Subject: **Request for Modification to Individual Section 404 and Section 401 Water Quality Certification** for the proposed construction of an extension of SR 1163 (Old Georgetown Rd) from SR 1184 (Ocean Isle Beach Rd) to NC 179 in Brunswick County, State Project 6.231023, TIP R-3432. Debit \$570.00 from WBS 35501.1.1

The purpose of this request is to modify the above referenced 404 Permit and 401 Water Quality Certification. Please see enclosed copies of the revised permit drawings and revised NCDMS acceptance letter for the above referenced project.

In order to prevent scour and undercutting the following revisions have been made:

PERMIT DRAWING
SHEET 8 OF 29
REVISED 10/12/2015

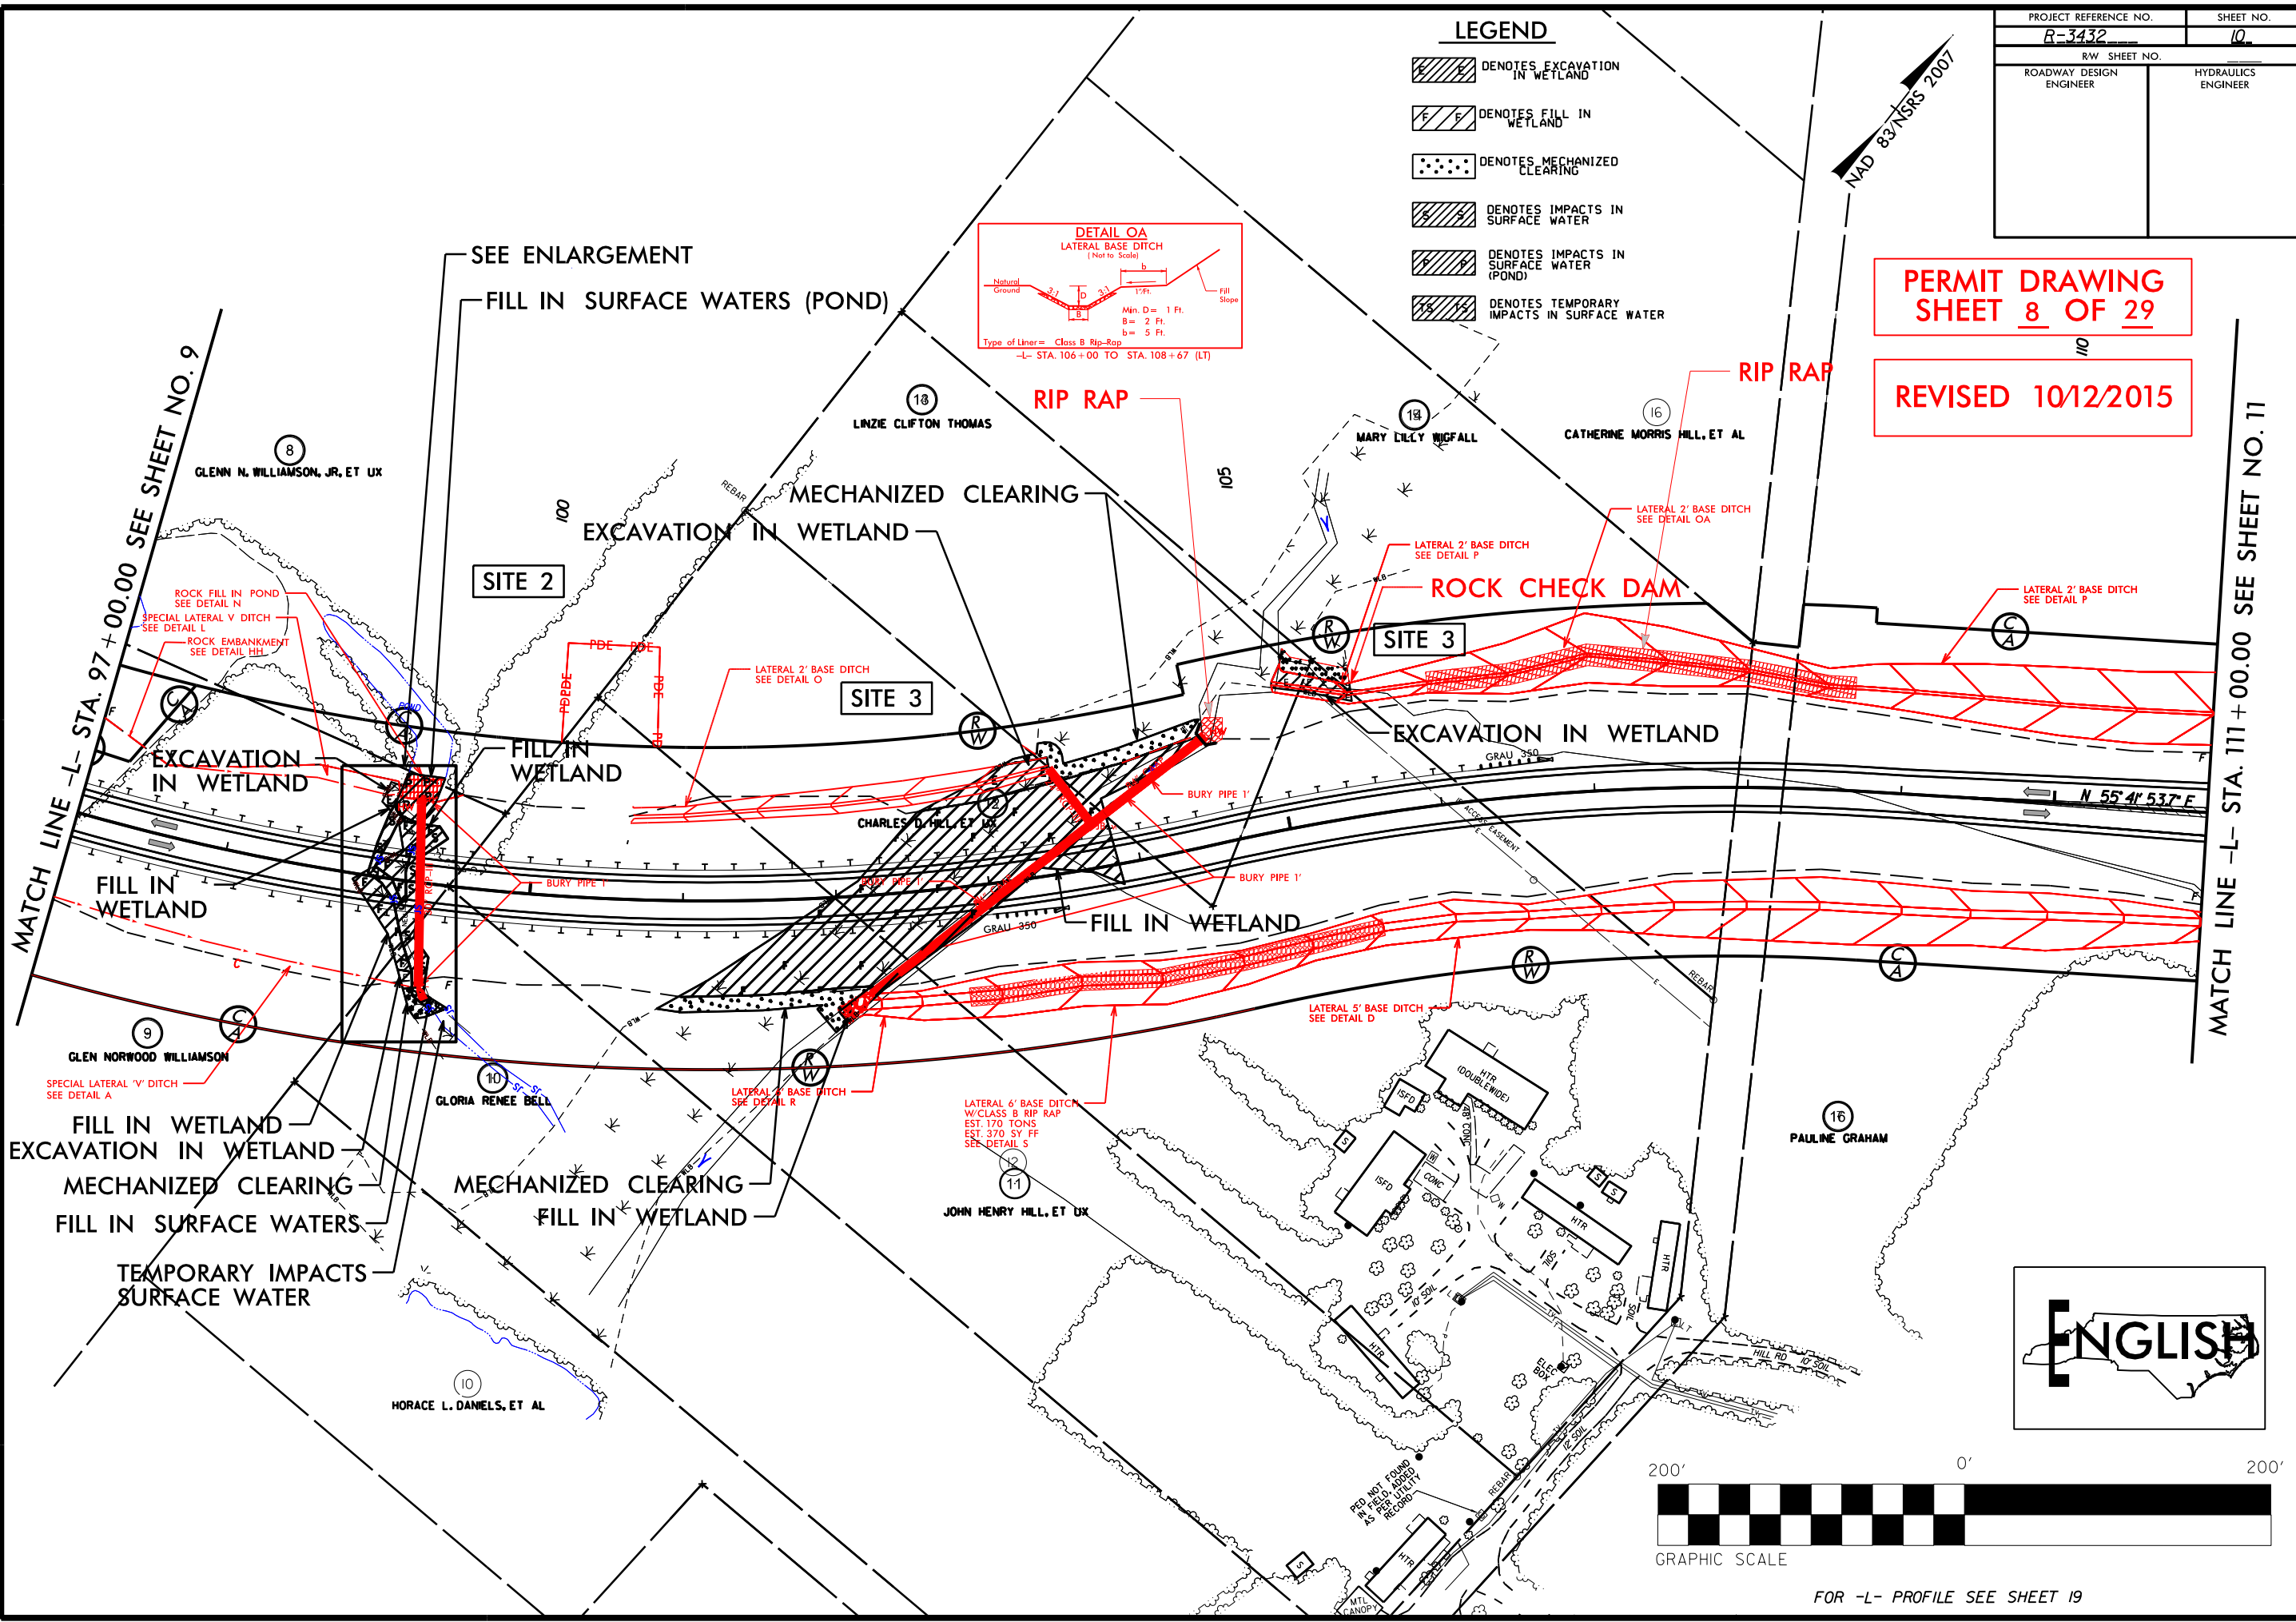
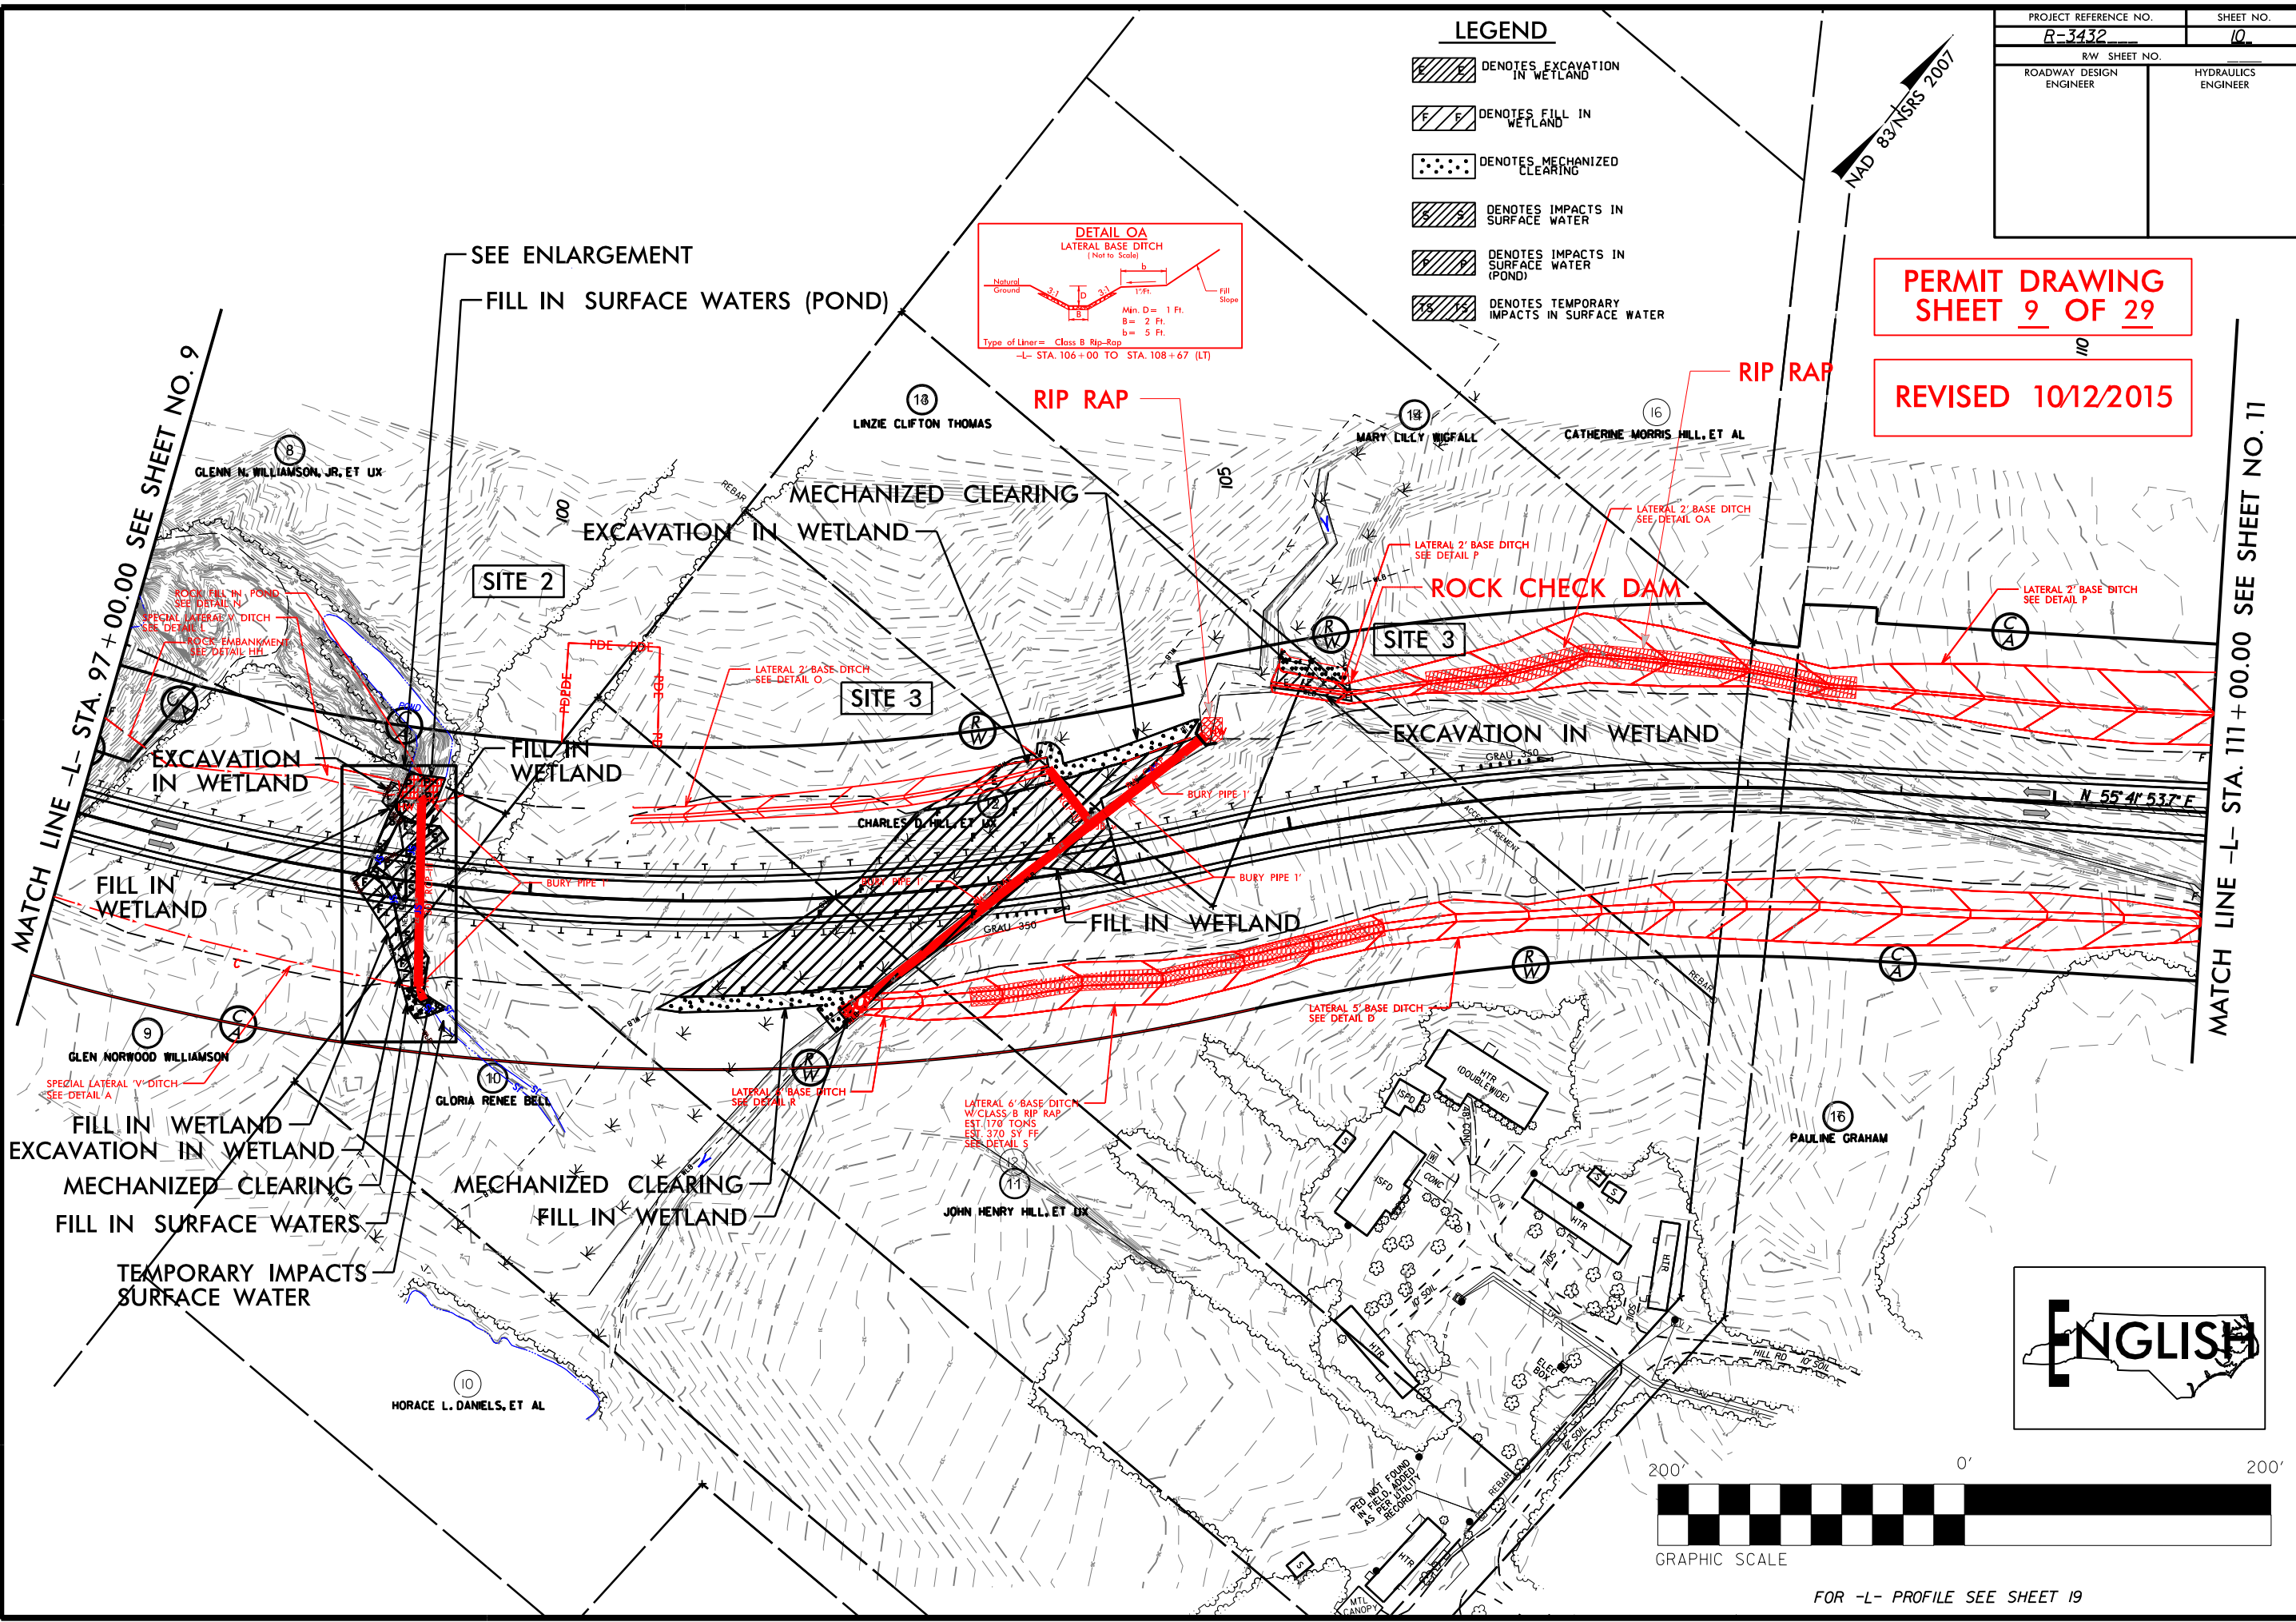
- Site 1. Additional riprap will be added at the inlet of the 84" CAAP. Surface water impacts will increase by 0.1 acre.
- Site 2. Additional riprap will be added at the outlet of the 30" RCP in prior permitted permanent impact areas. Mechanized clearing is increasing by 0.01 acre in prior permitted permanent impact areas.
- Site 3. Additional riprap will be added at the inlet of the 72" CAAP in prior permitted permanent impact areas. Mechanized clearing is increasing by 0.02 acre in prior permitted permanent impact areas with a decrease of 0.03 acre of excavation.
